From: Michael Eastham <Michael.Eastham@arun.gov.uk>
Sent: 06 November 2019 09:38
To: Planning.Responses <Planning.Responses@arun.gov.uk>
Subject: FW: Saltbox - BE/110/19/DOC - Conditions 9 and 10

From: Roger Spencer <Roger.Spencer@arun.gov.uk>
Sent: 05 November 2019 16:21
To: Michael Eastham <Michael.Eastham@arun.gov.uk>
Cc: Paul Cann <Paul.Cann@arun.gov.uk>
Subject: RE: Saltbox - BE/110/19/DOC - Conditions 9 and 10

We have now looked at your further proposals, our comments are below;

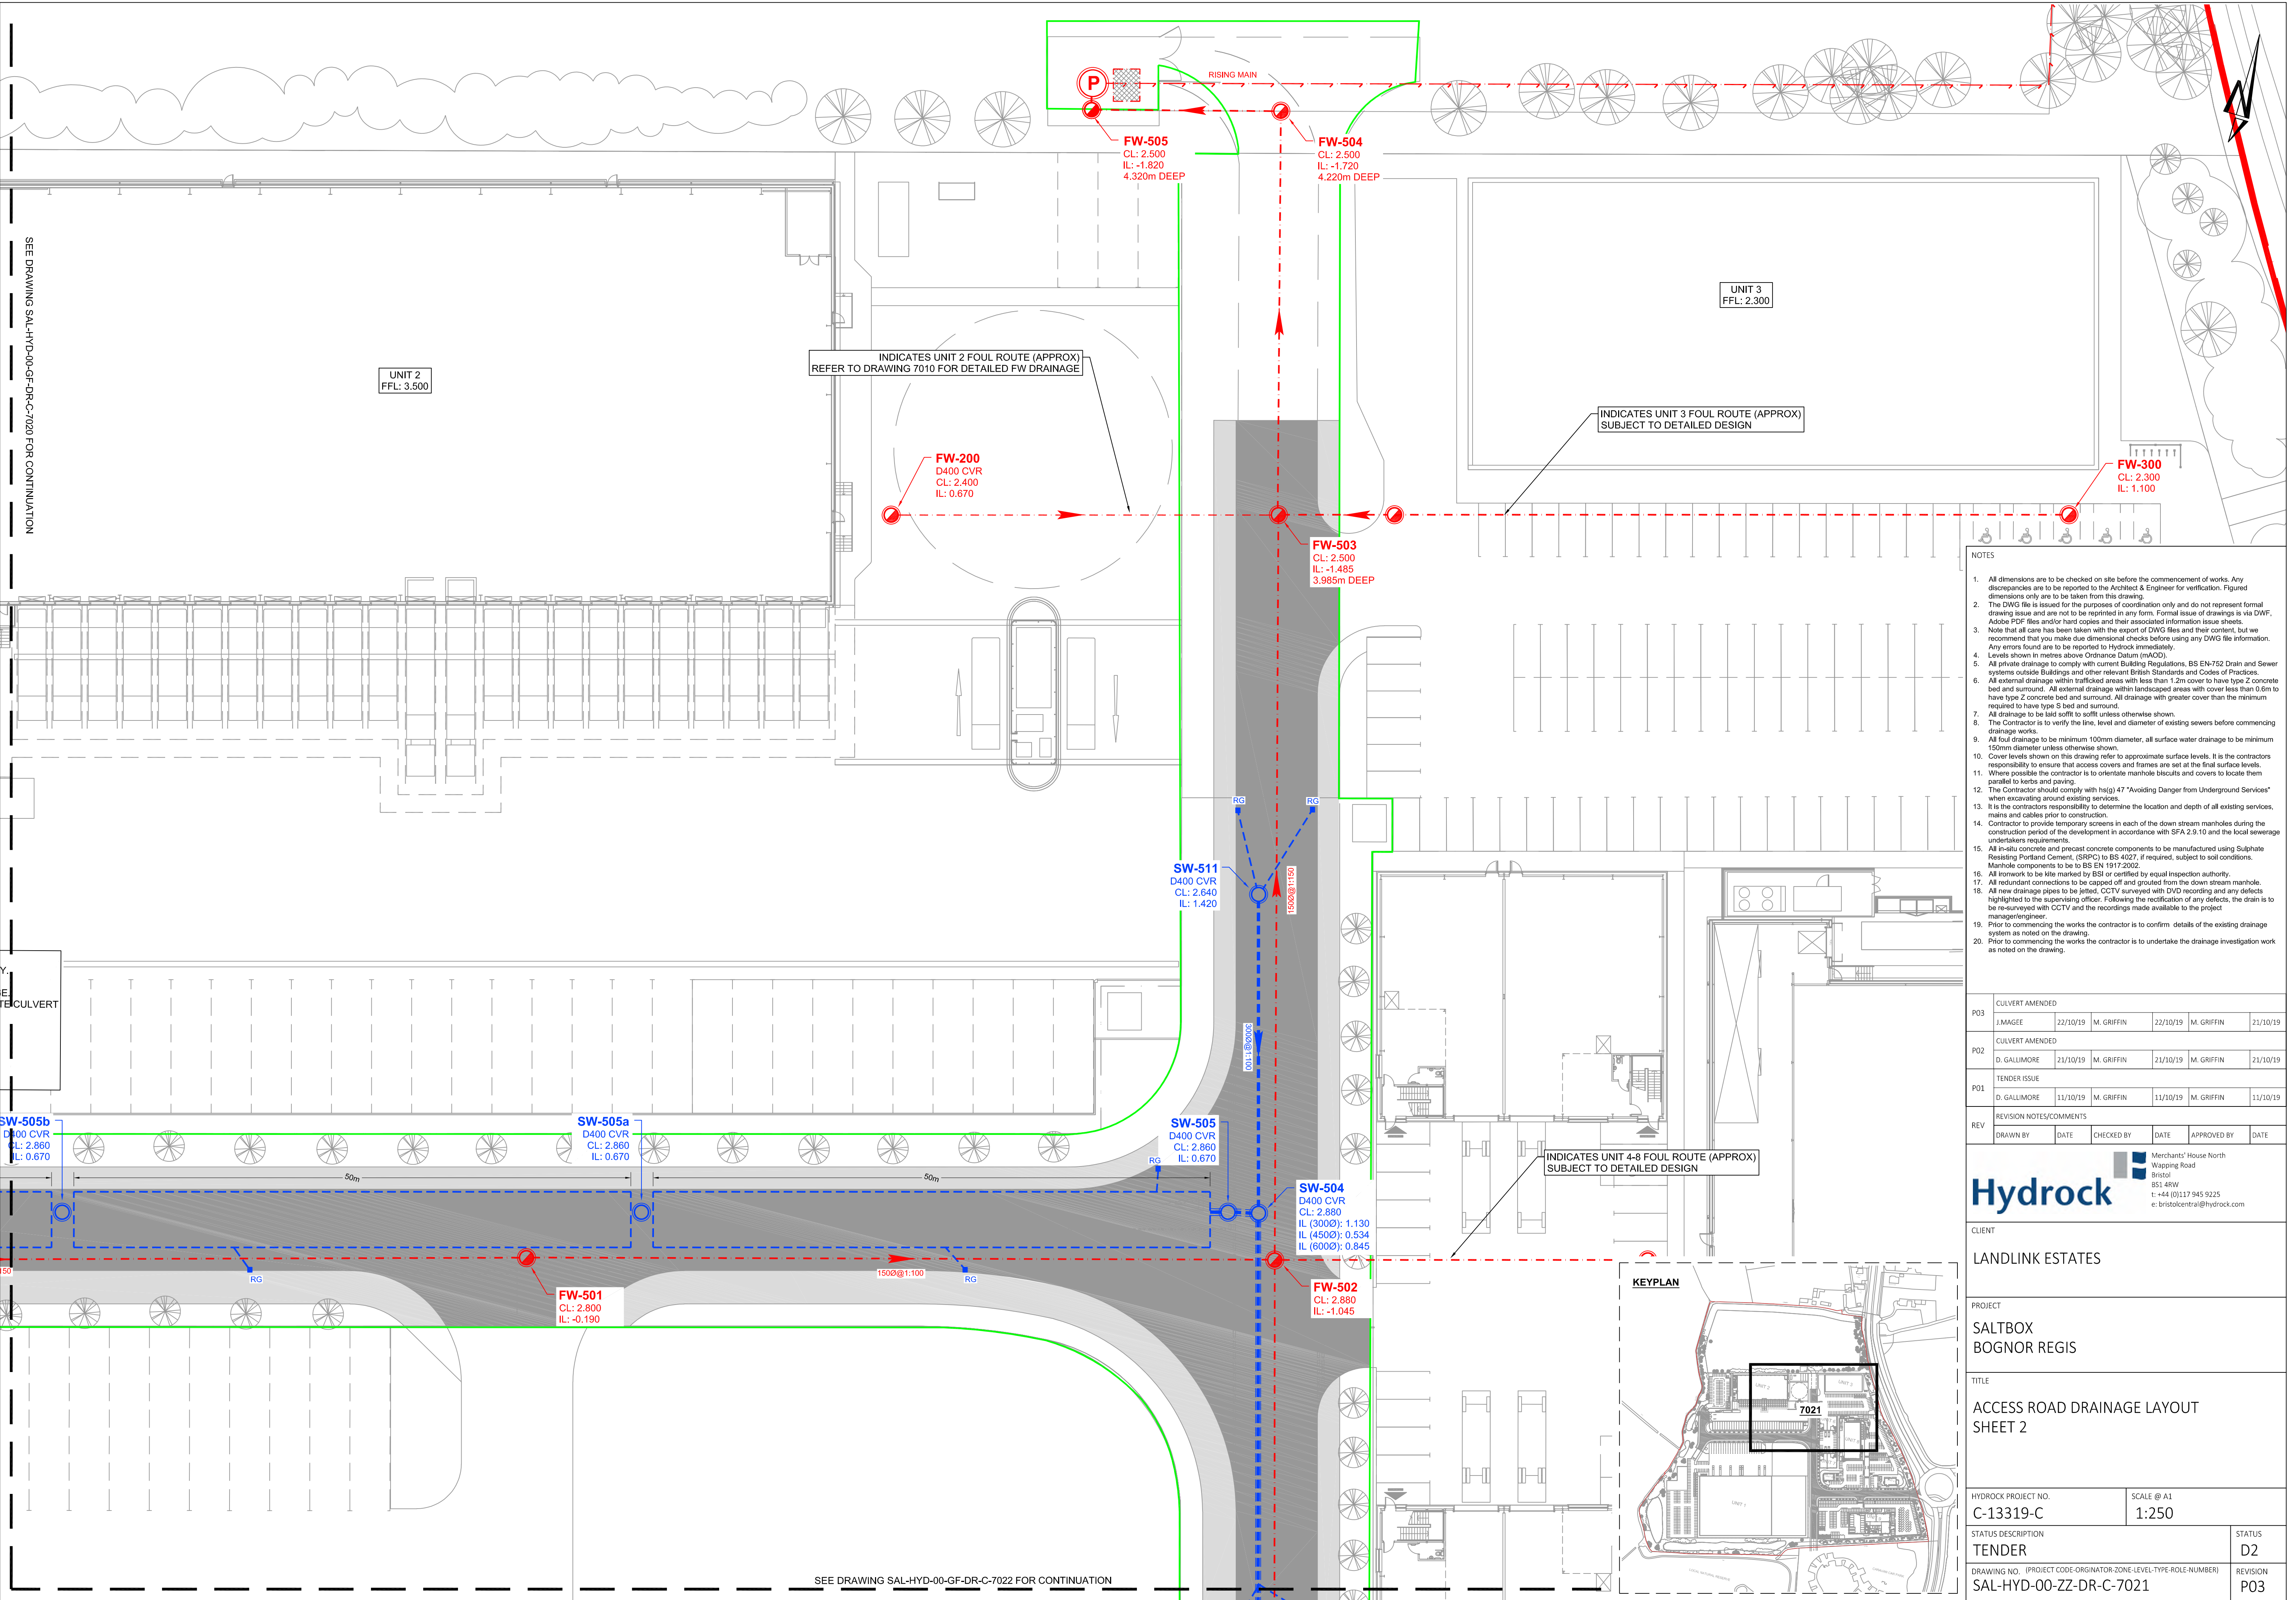
1. The stretch road of from hammerhead by the foul pumping station towards manhole SW-511 does not appear to have any surface water drainage associated with it. Please advise/detail.

2. Pipeline SW-507 to the headwall is showing planting over/within close proximity. Please remove as necessary.
3. The concrete box tank appears to have no gradient. Please rectify to ensure self-cleansing in the low flow channel.

4. Provide a plan showing finished levels for the road.
5. Specify pipe diameters/gradients from control manhole FC-501 to oil interceptor and FC-501 to box tank.

6. Provide fully detailed construction drawing for box tank, including low flow channel within.
7. There is minimal cover to the box tank – please provide structural calculations to ensure no detriment due to vehicle wheel loadings/movements.

8. Provide fully detailed construction drawing for the manholes between the box tank sections and showing their connectivity with the tank. All these to be catchpit manholes. The plans need to clearly indicate which are catchpits as there are some discrepancies between drawings.

9. All road gully connects to tank to be made at soffit to soffit level or near as possible. Add notes.
10. One road gully is on top of the box tank and would not be possible to construct and would also result in an unacceptable connection into the top of the tank . Please reconfigure as necessary.

11. Manhole SW-505 to be catchpit manhole.
12. Manhole SW-504 - 450mm connection not connected at soffit at soffit level and the invert is lower than the downstream invert. The 300mm connection into this manhole needs a slight adjustment to make it connect at soffit to soffit level.

13. Specify pipe diameters/gradients between manhole SW-505 and box tank.
14. Manholes SW-508 & SW-509 – Specify D400 covers as opposed to B125.
15. Where road gullies are being connected to pipelines, oblique 45 degree junctions to be used, ensuring the connection is made at 10 or 2 o'clock, as per a clock face, assuming to the top of the pipe being connected to is 12 o'clock. Add note.

16. There are numerous types of road gully as per the construction detail. Specify which type applies to each gully.
17. Gully near manhole SW-503 – connect into manhole rather than onto the pipeline.

18. Clearly indicate on plans which manholes are to be catchpits.
19. Headwall – An activity permit is required from the Environment Agency for the connection to the 'main river'. This will include their agreement to the headwall construction, discharge of flows and erosion control measures. Add a suitable note.

20. Despite item 19, please include rocker pipes on the construction detail. Reference to drg. 7020 should refer to the layout arrangements rather than 'details'. A construction detail is required for the concrete protection slab pipe protection and the full extent of this type of protection shown on the drawings. A flap valve to be specified on the end of the pipe.

21. Control chamber FC-501 – cover level differs between plan and construction details. Construction drawing to be fully detailed ie. dimensions, ring diameter, materials, etc.

22. Manhole SW-507 – is this manhole required?
23. Specify pipe materials for all pipelines.
